RESPONSE TO SUBMISSIONS LETTER - TRAFFIC/VEHICLE MOVEMENTS

TTPP REF: 16222

RE: Proposed Resource Recovery Facility, 20 Hearne Street Mortdale (SSD 7421)
Response to Submissions

Figure 2: Areas of Site Supervision

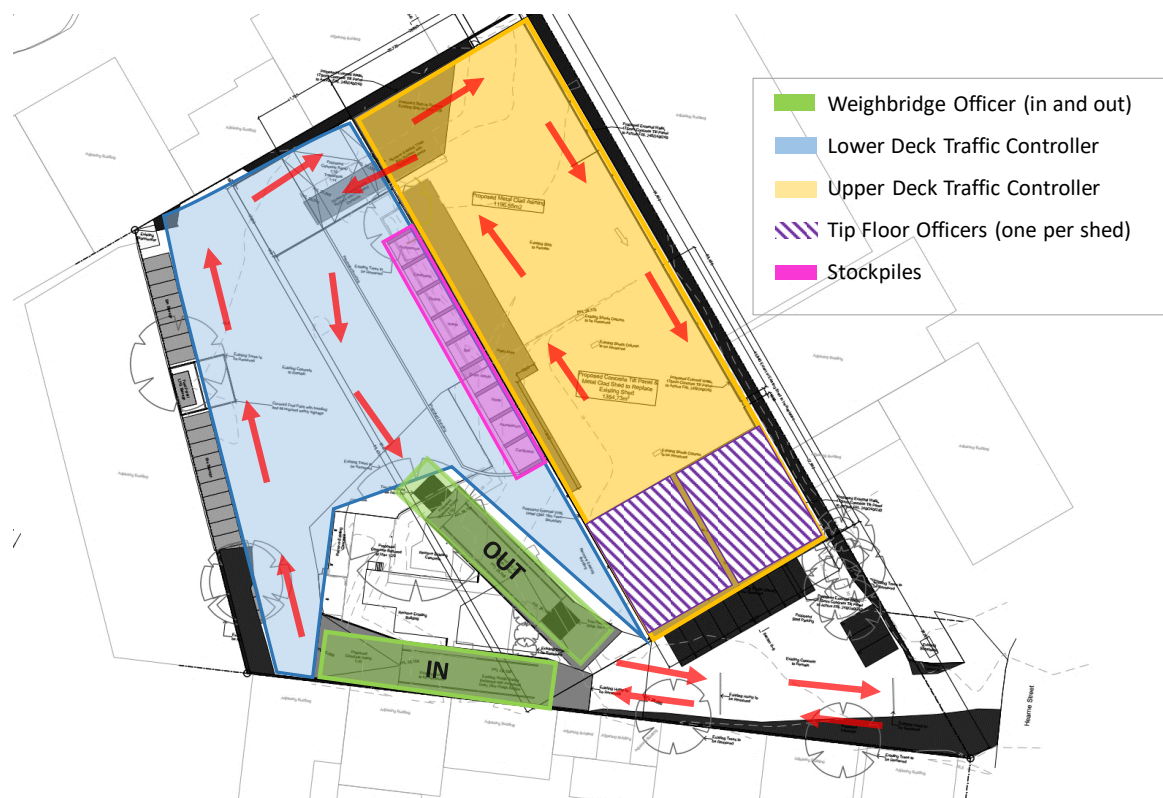
Additional information provided in TIA Letter, however the information lacks any detail regarding management of trucks at the site entry. Figure 2 depicts traffic controls which are all internal - there are no proposed controls at the entrance to avoid conflict with vehicles entering and exiting. If an exiting truck takes a wide berth, an incoming truck would not be able to enter.

Further details are required regarding management of vehicles entering and leaving the site to avoid queuing within the road reserve and traffic safety issues.

Traffic movements at the site access would be managed by implementing the following controls:

- Two-way traffic flows would be delineated by arrow stencils on the driveway. Traffic flows into and out of the site would be separated by a double barrier line (two-way). Delineation on the driveway would be provided in accordance with the design specification in RMS' Delineation Guidelines Section 4 – Longitudinal Markings and Section 10 – Pavement Arrows. Providing linemarking in line with RMS guidelines would ensure driver familiarity of information portrayed by the linemarking and to follow instructions accordingly.

- A Left Arrow Only sign is to be erected at the site access to instruct all drivers exiting the site to turn left when entering Hearne Street. As currently practiced, drivers would be informed of the approved haul routes to the site as part of their staff induction. Emphasis would be placed on the routes into the site via Hearne Street to/from the north, and that access via Barry Avenue is not permitted.

- A traffic controller would be stationed at the driveway access during site operation to supervise traffic movements on the driveway and on Hearne Street, near the site access.

The above controls at the site access are illustrated in Figure 1 while designated areas of supervision by site staff are shown in Figure 2. A traffic control plan showing measures across the entire site is provided in Attachment A.

PROJECT	BINGO, MORTDALE		
TITLE	19.0m SEMI-TRAILER AND 8.8m MRV - SWEEP PATH

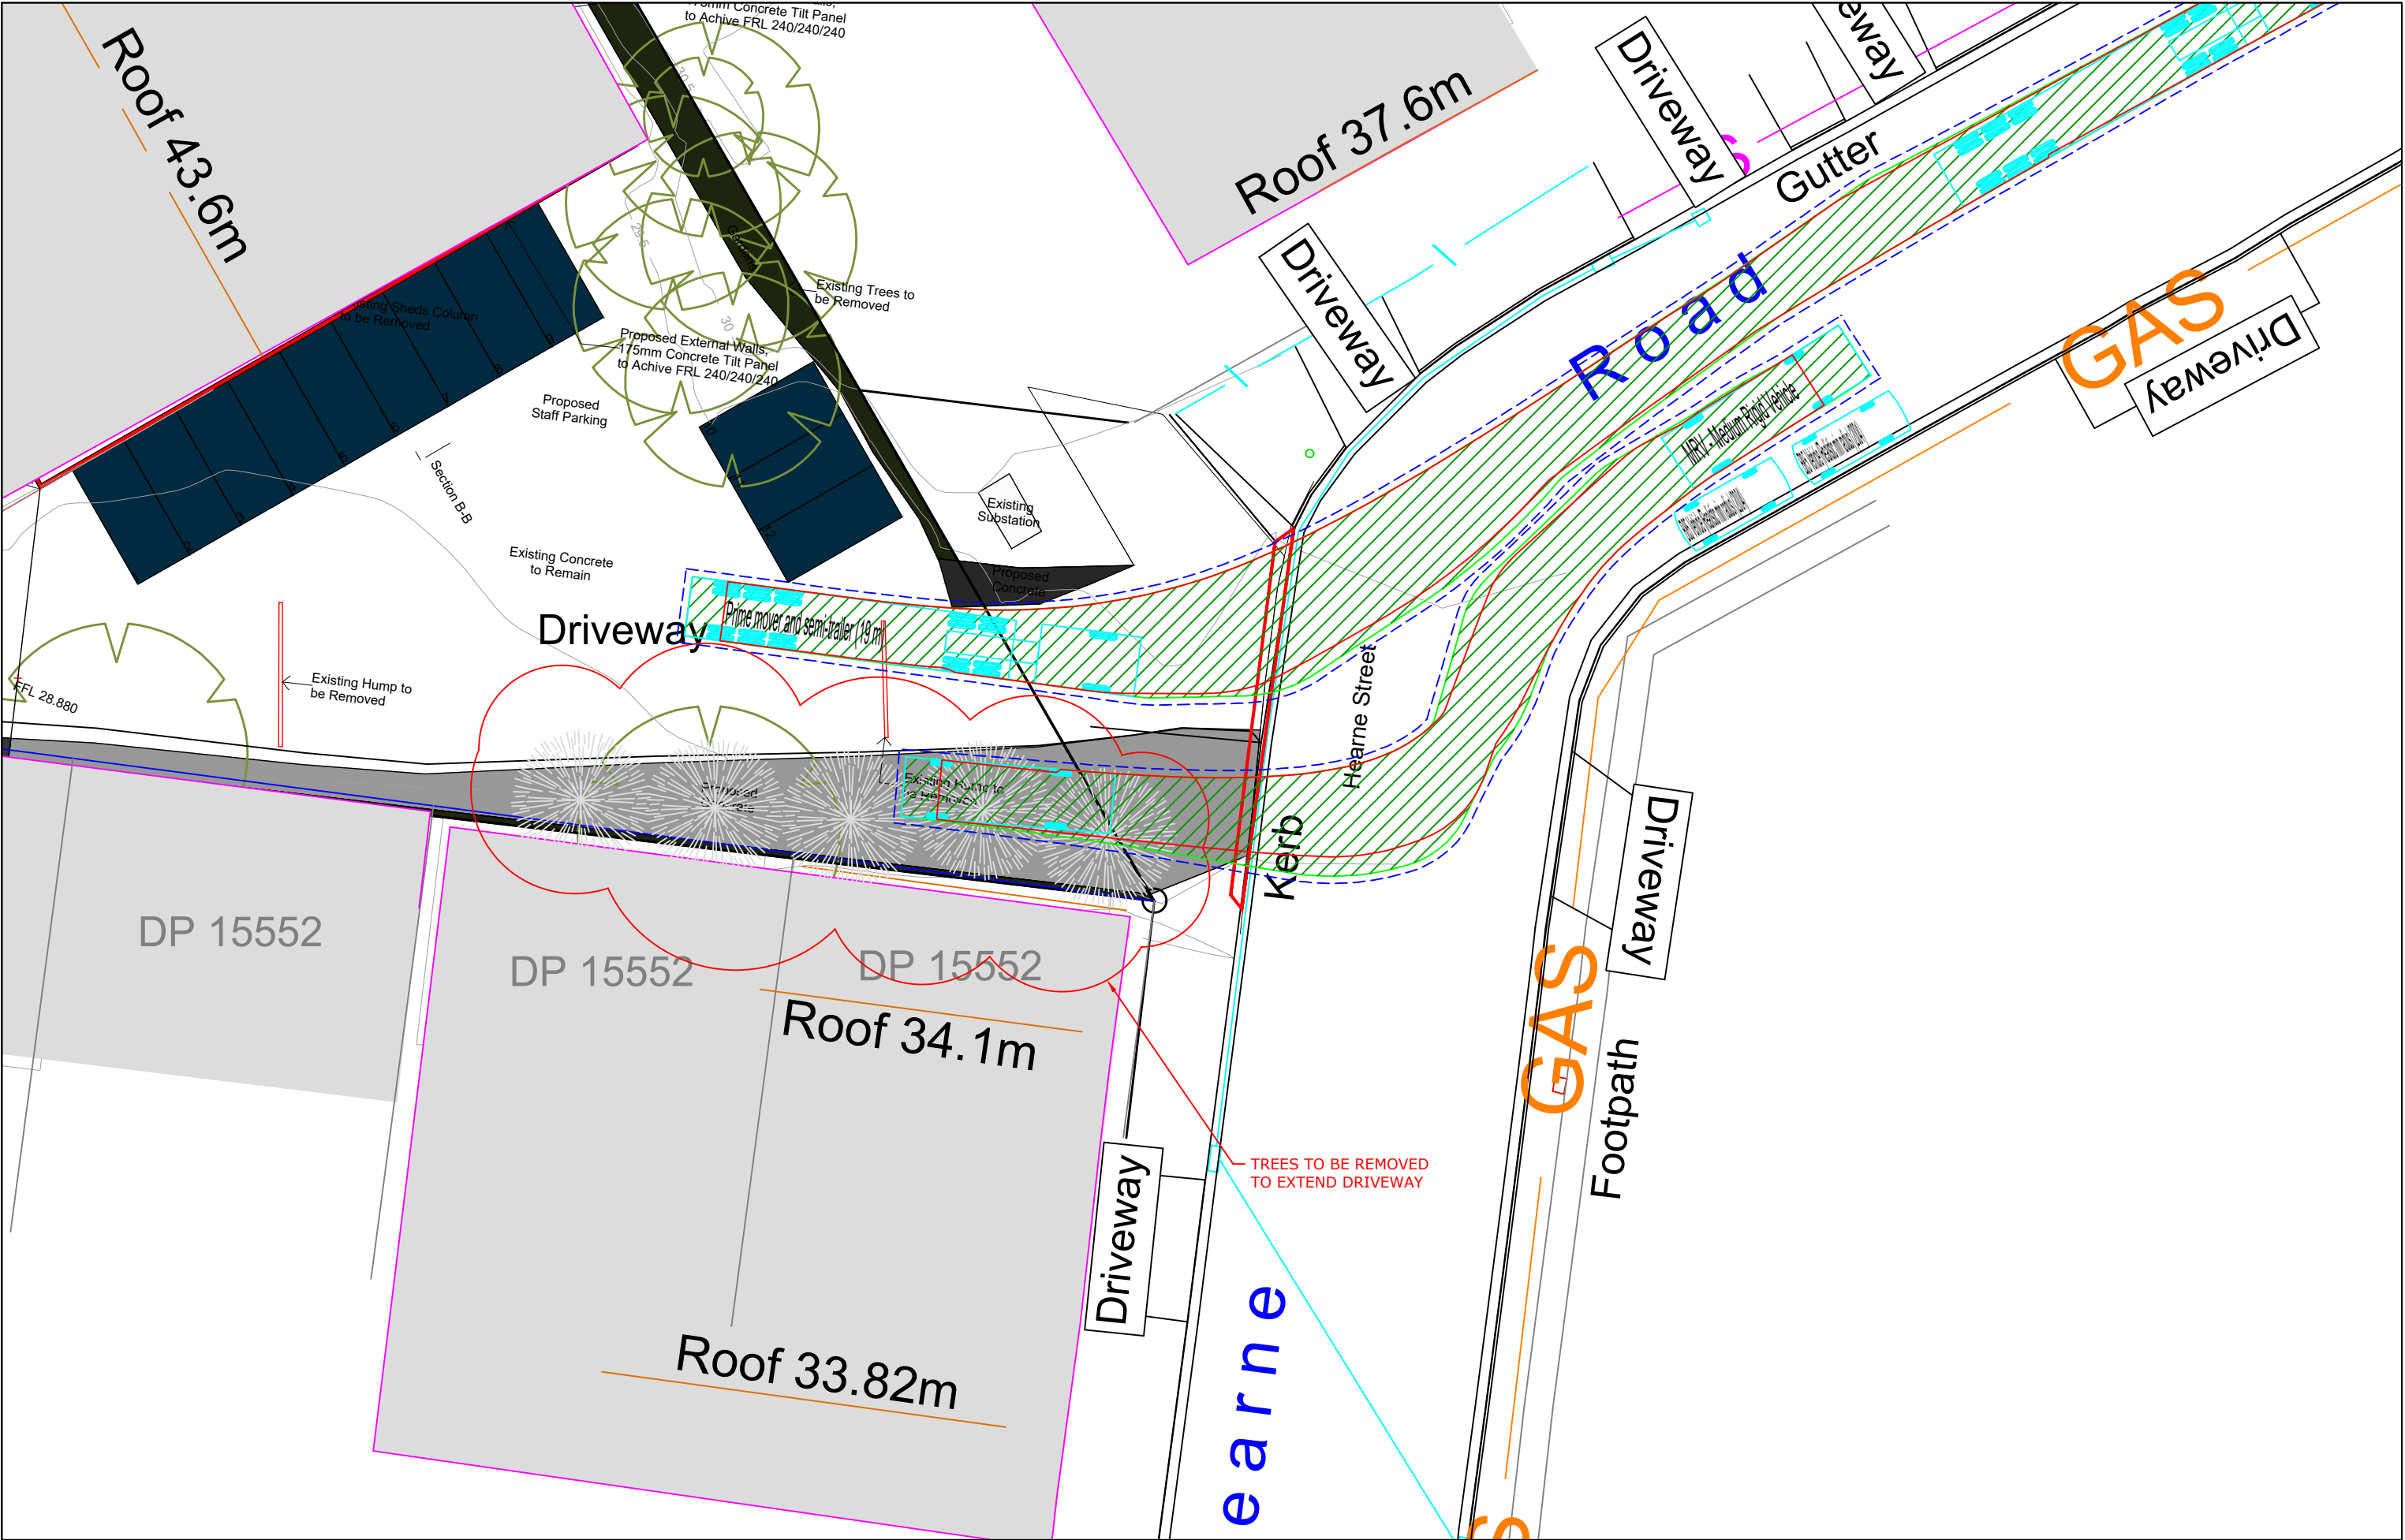
A stacking plan has been provided which only shows the stacking of heavy rigid trucks on site. There is no plan showing the stacking of semi-trailers collecting sorted materials. There is no indication of how traffic will be controlled at the access way. In particular, how will trucks be directed to the stacking locations. Further, the stacking plan contradicts the internal turning path diagrams with vehicles stacked in areas required for manoeuvring. Further clarification is required.

Control measures to be implemented at the site access have been detailed in the response to *DPE Item 1*. Direction given to drivers to proceed to the stacking location is also explained in the response.

A stacking plan showing the larger waste collection vehicles (semi-trailers and truck-and-dogs) is provided in Attachment C. The stacking arrangement and level of adequacy is discussed in detail in the response to *Council Item 5*.
